12 October 2021

Our Ref: R/2017/14/Q  
File No: 2021/444510  
Your Ref: SSD 8517 – MOD 7

**Locomotive Workshop – SSD 8517 MOD 7 – Expand retail uses into Innovation Plaza – Response to submissions**

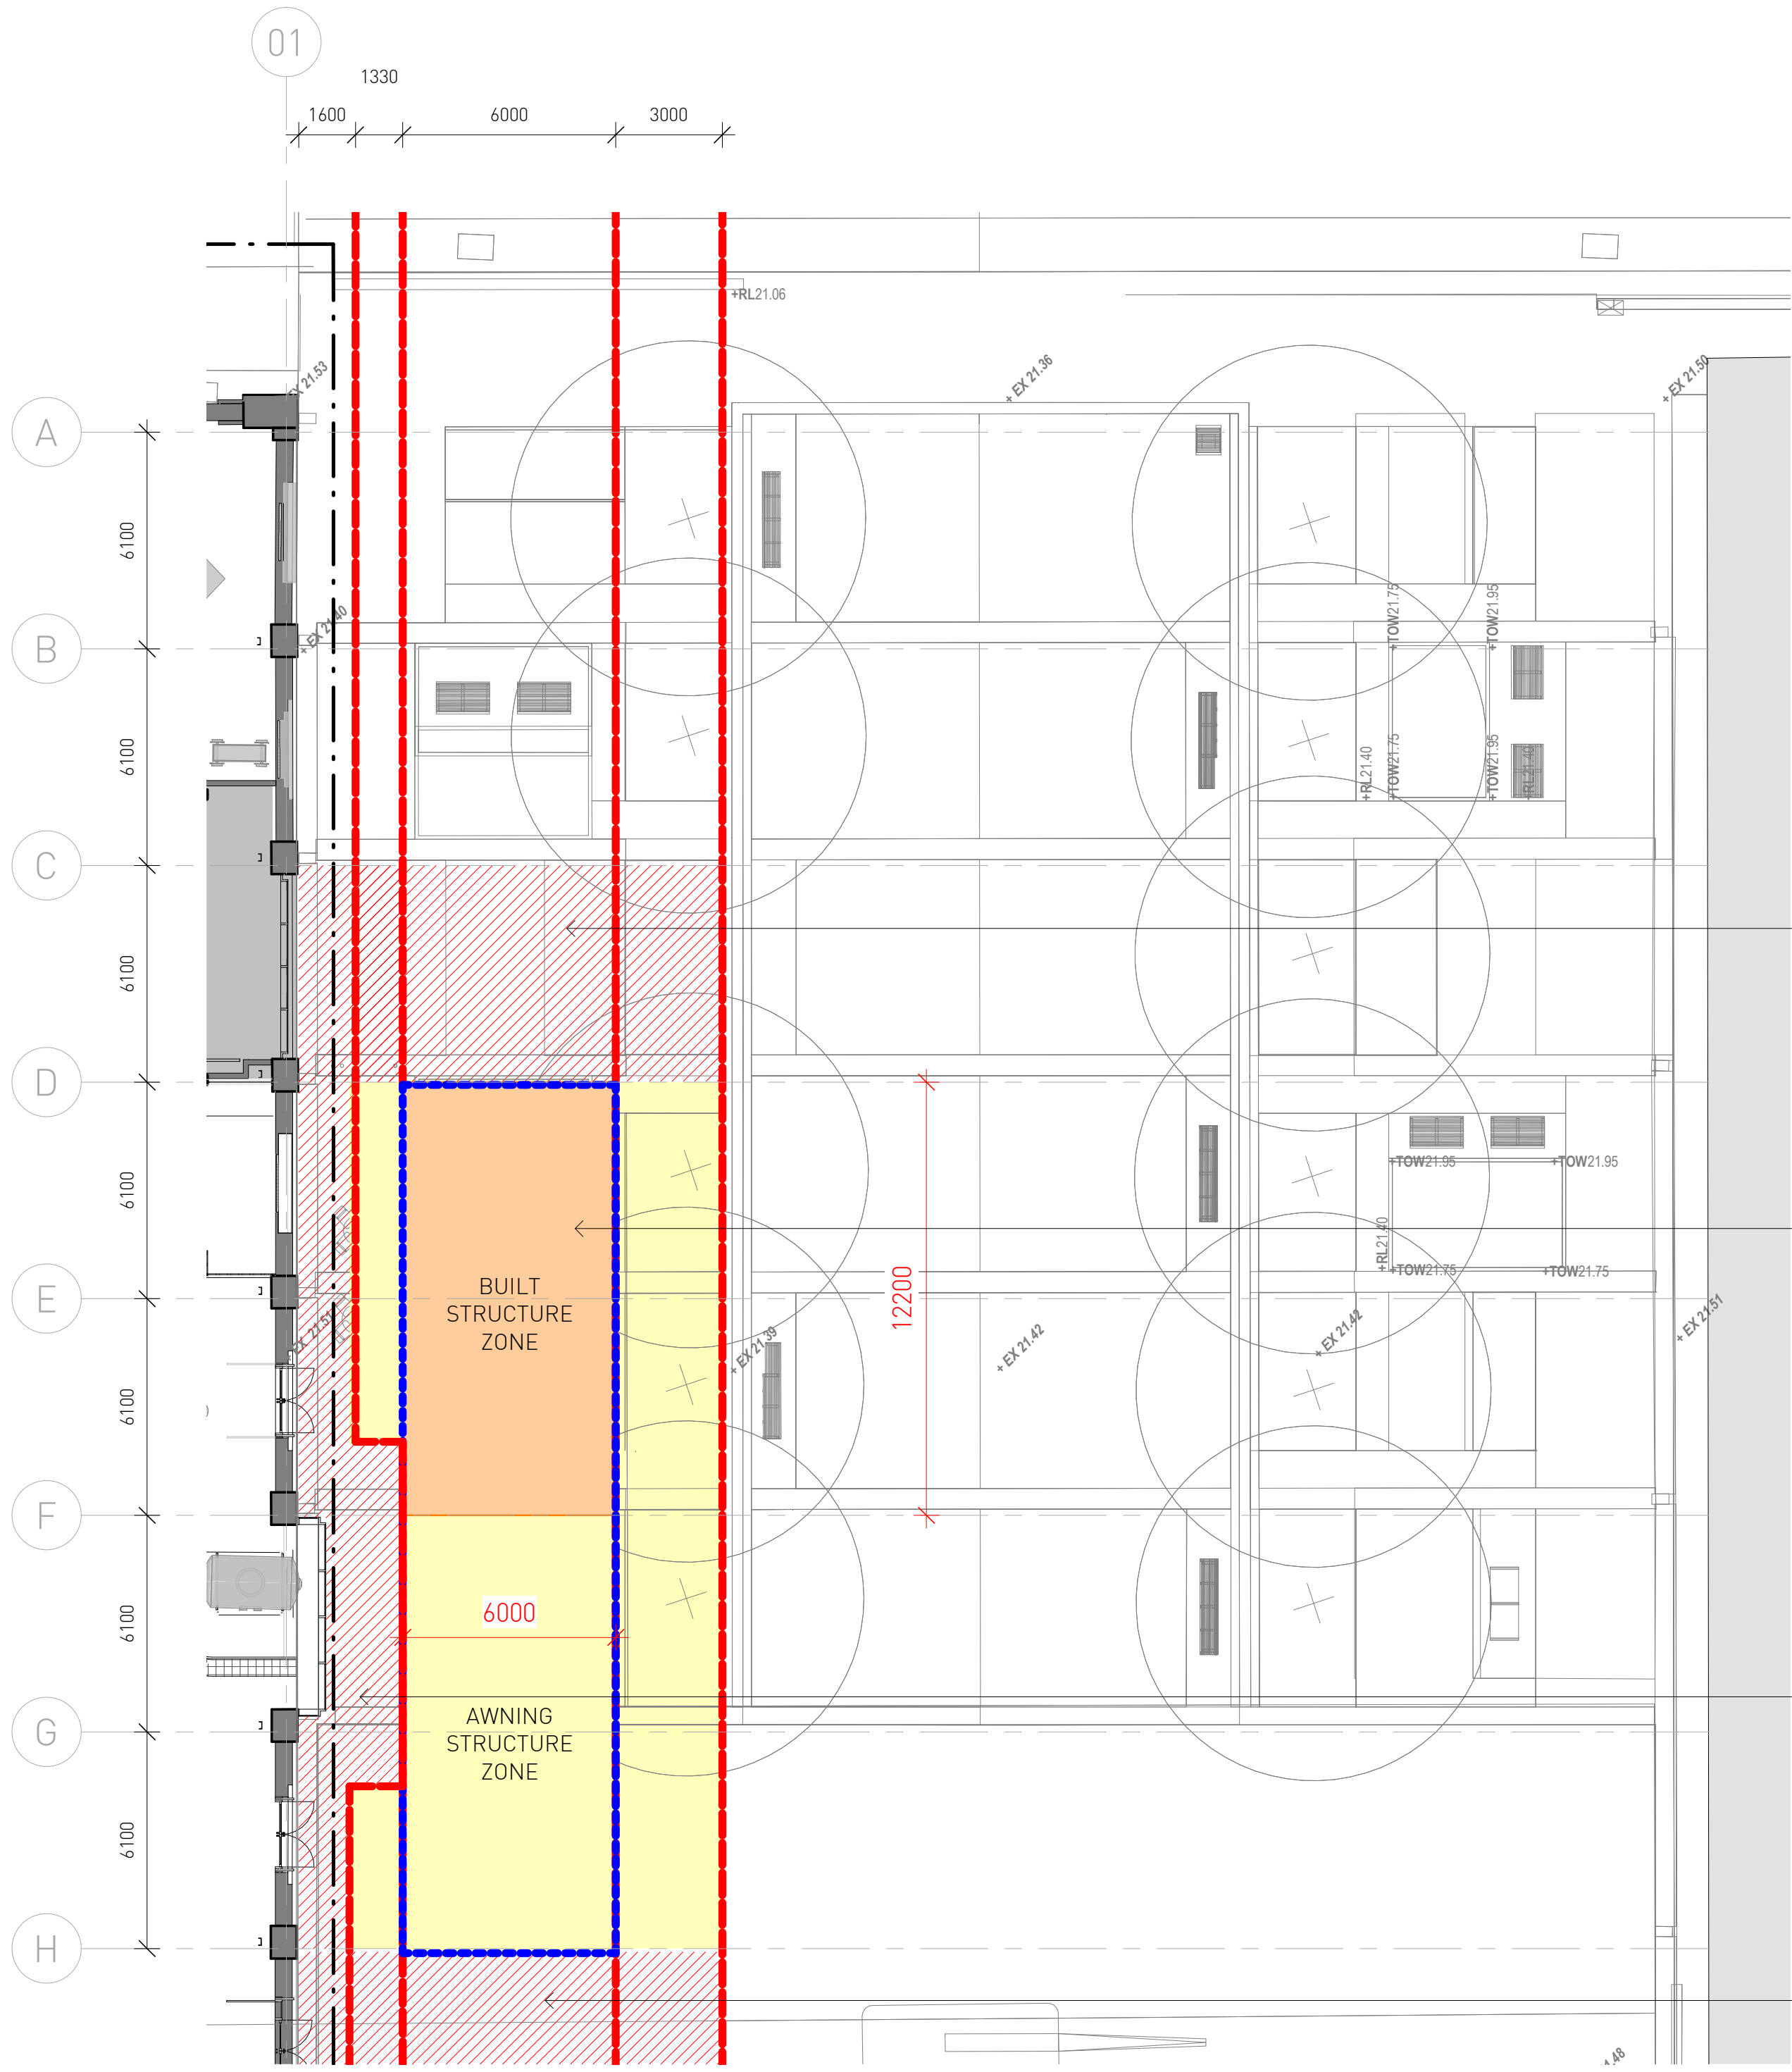
The proposed mass planting below the existing mature trees is not supported and is recommended to be removed from the plans. The proposed planting is within the Structural Root Zone of the existing trees and would likely impact existing roots. Furthermore, the existing trees would have to compete with the new plants for water and nutrients and likely to affect the health of these significant trees, which currently add to the environmental amenity and character of Innovation Plaza and the use of this public space throughout the year.

2 L0 PLAN EXTRACT - INNOVATION PLAZA SOUTH
1 : 150

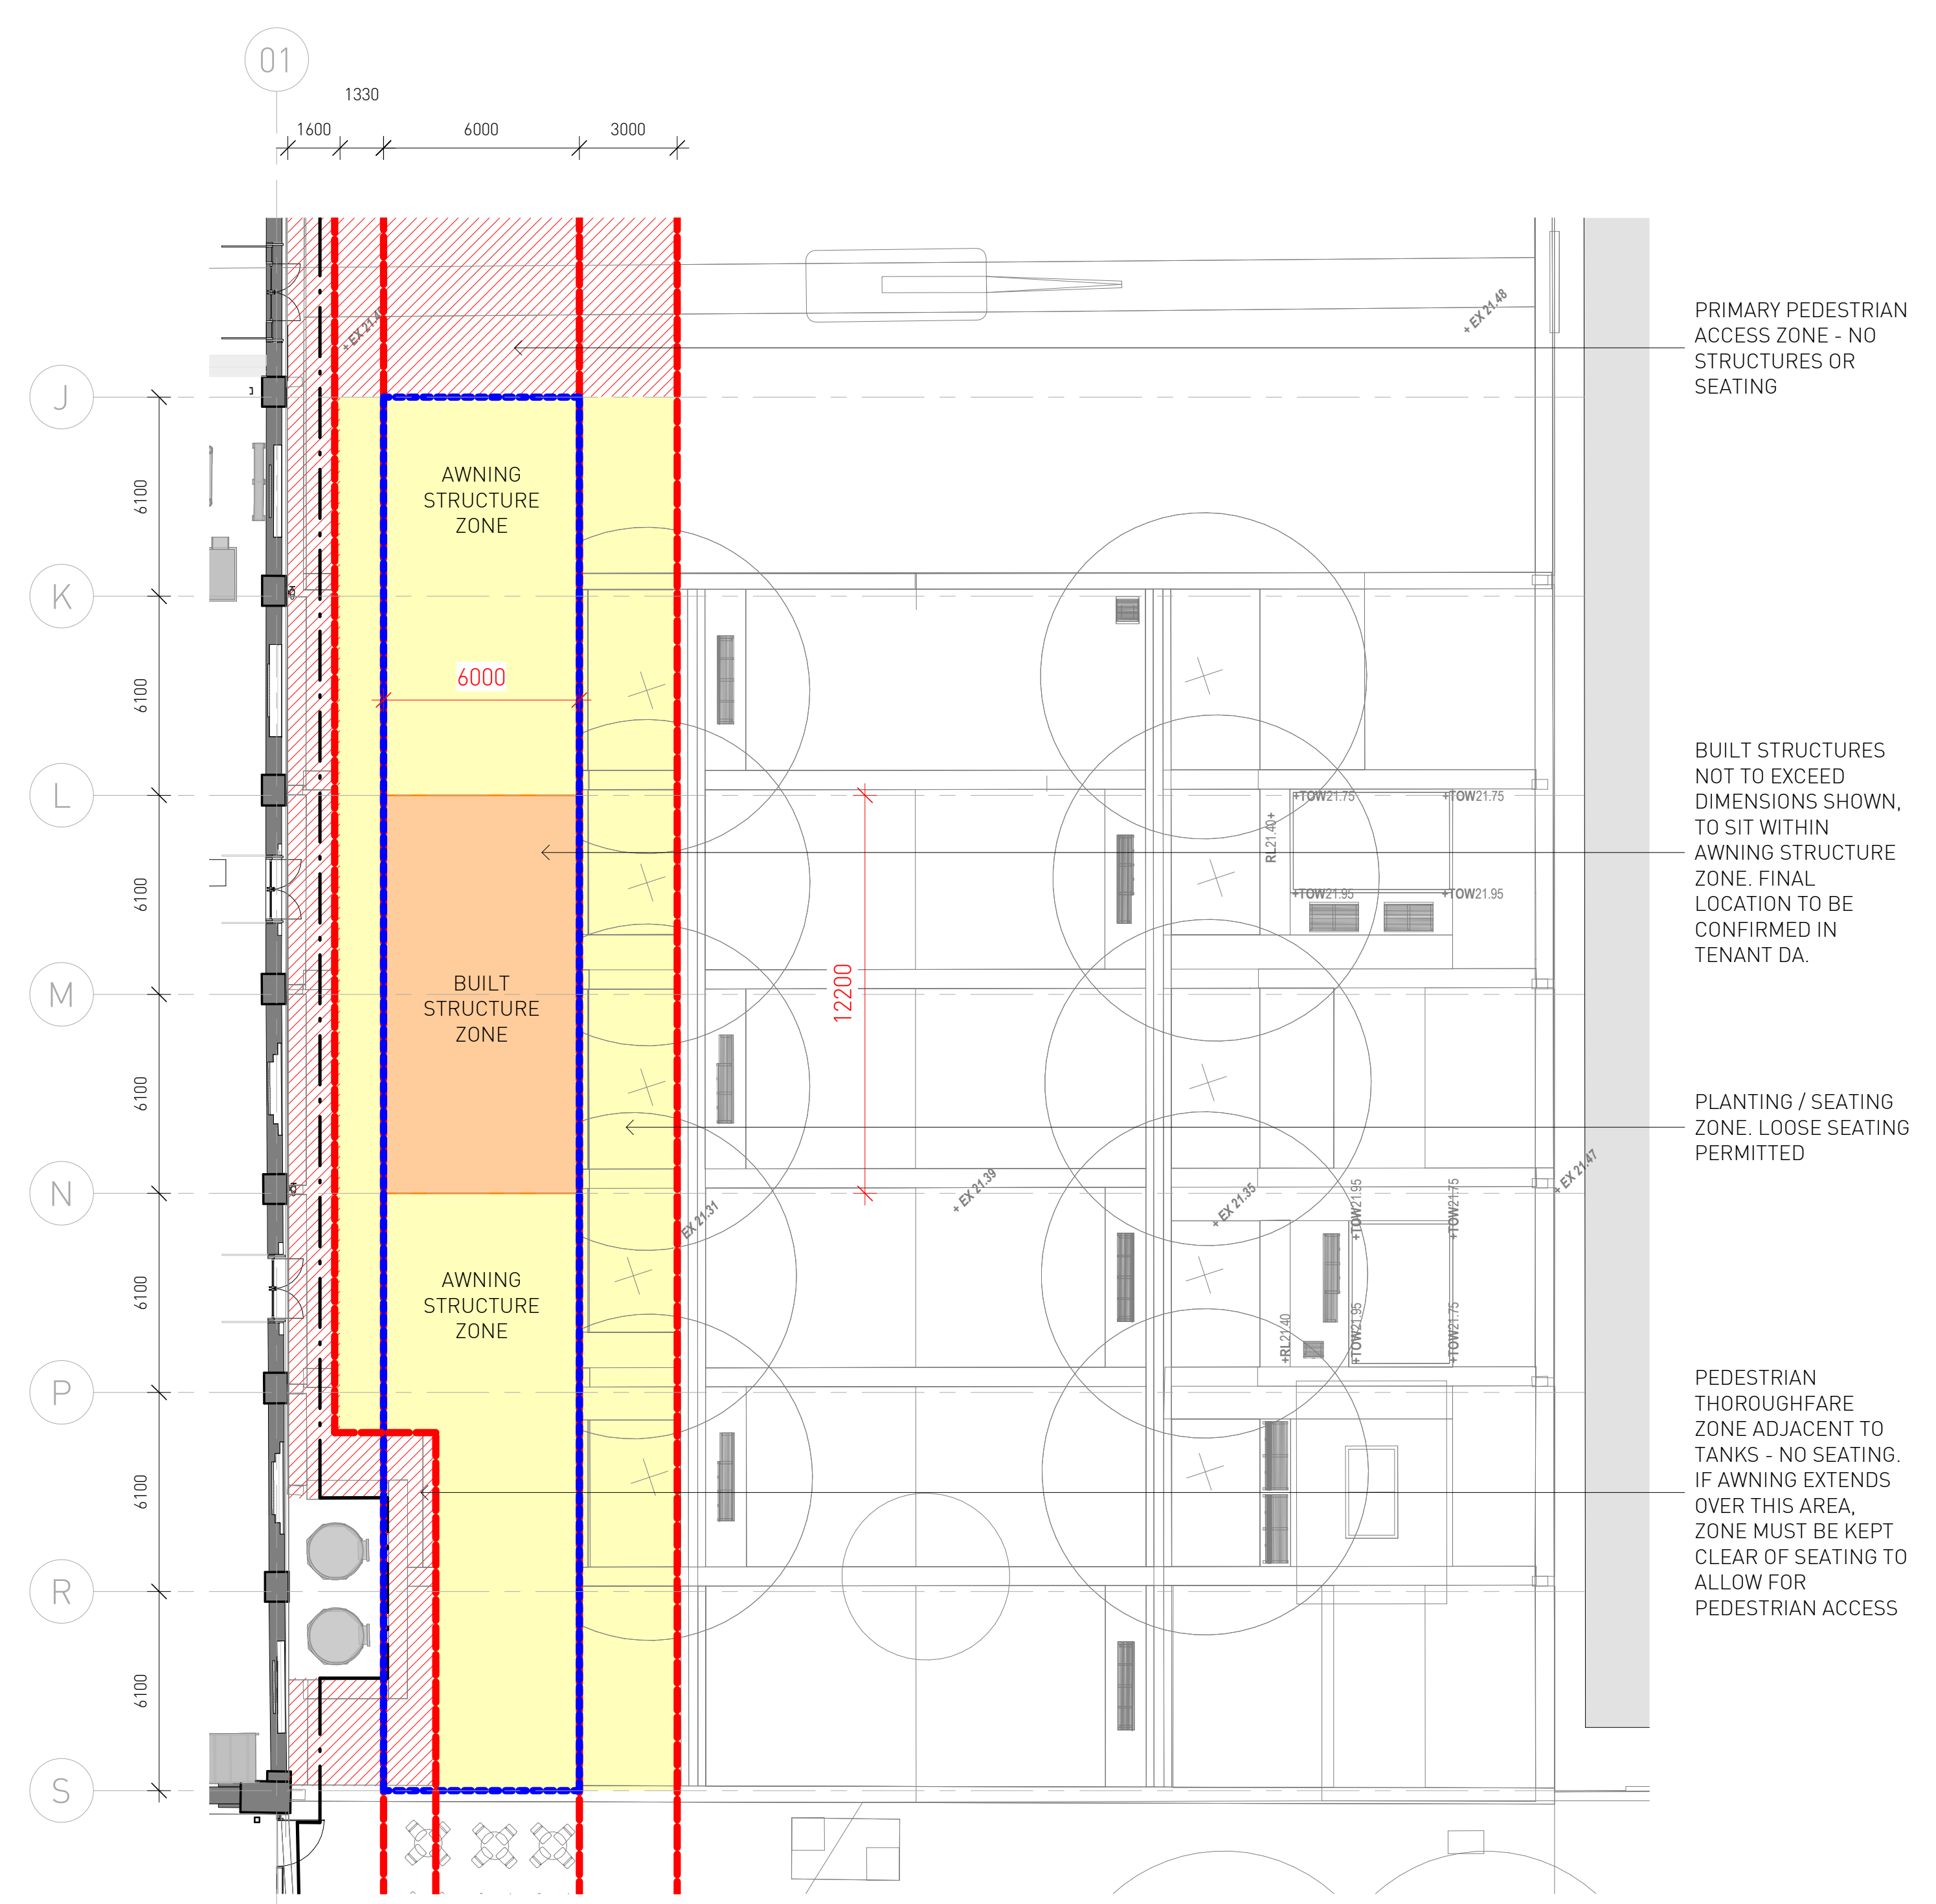
Council’s Public Domain unit have noted that the proposed seating area at the south of Innovation Plaza indicated in Figure 1 below creates a pinch-point on the footway at Locomotive Street, adjacent to the pedestrian crossing and Indigenous Garden. This access issue and hazard is exacerbated with the use of moveable furniture and is recommended to be removed completely. It is also noted that only the submitted landscape plans provide this detail and not the architectural drawings.

**Figure 1:** Seating area recommended for removal outlined in blue
